**Hills of Gold Wind Farm (SSD 9679)
Request for additional information**

Hills of Gold Wind Farm – Response to Submissions

Hills of Gold Wind Farm – Response To Submissions

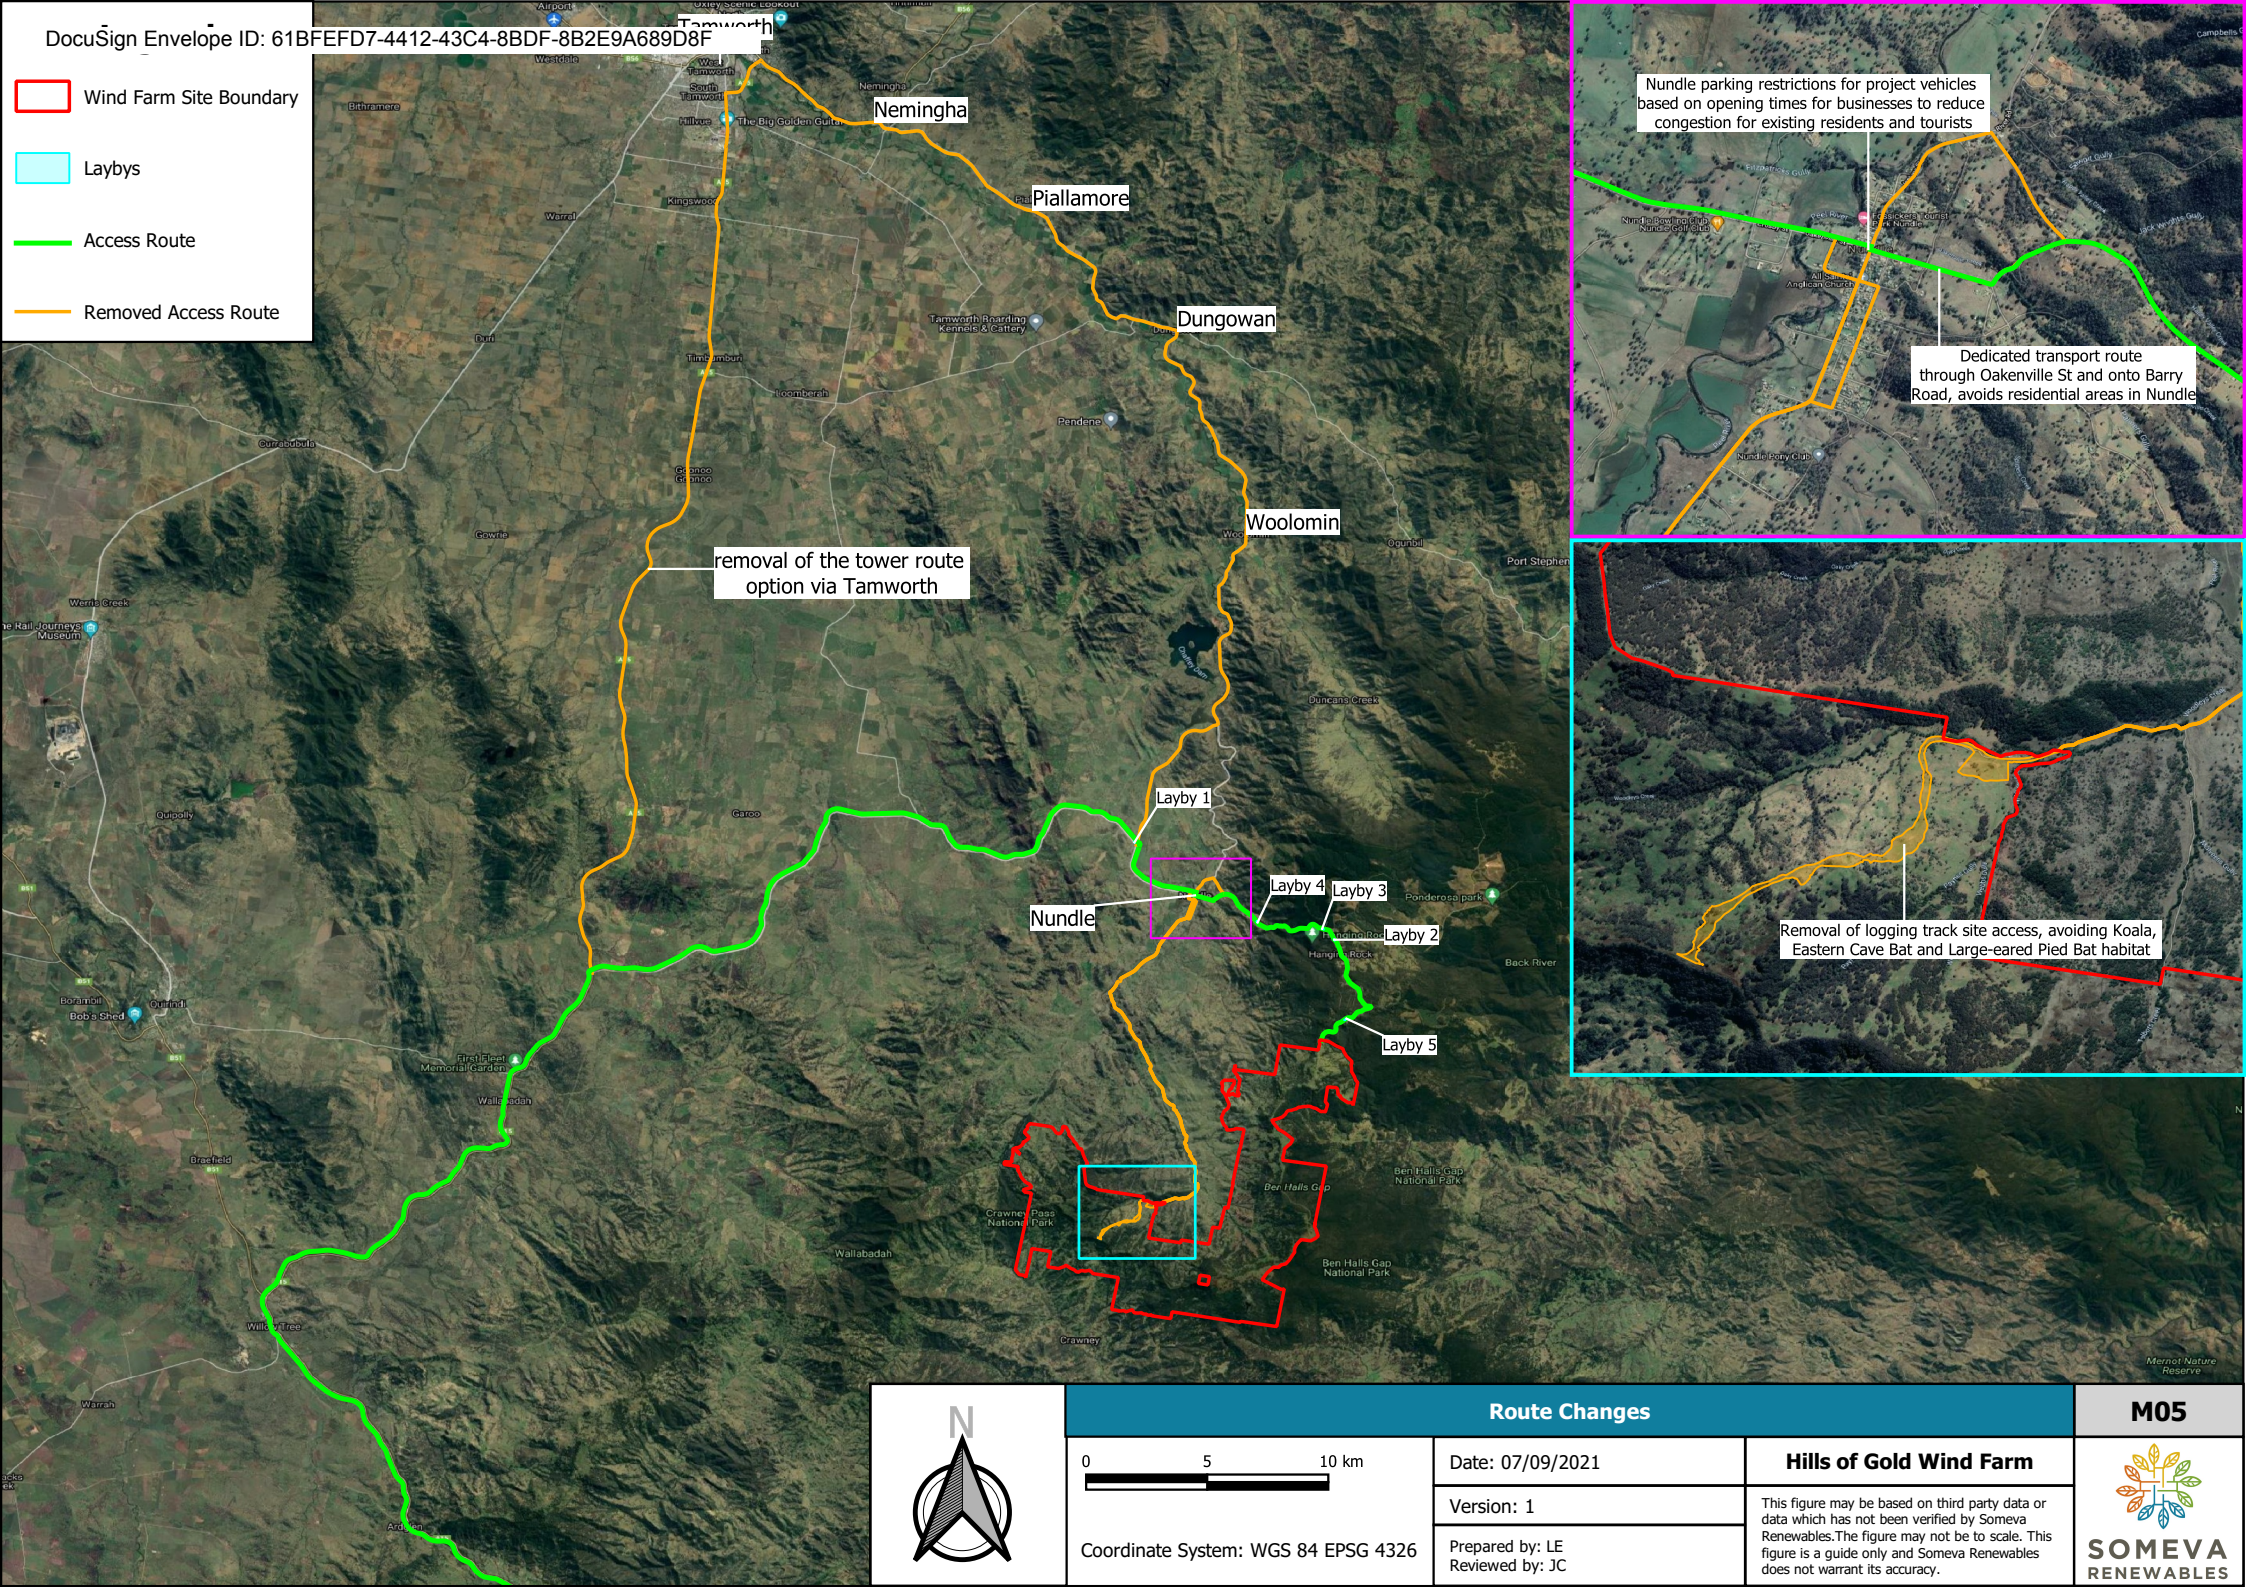
- **Transport** – further justification on why a private haulage road through Crown Reserve 85916 for Public Recreation is appropriate and necessary when alternative transport route options are available and considering the process required to secure access to this land;
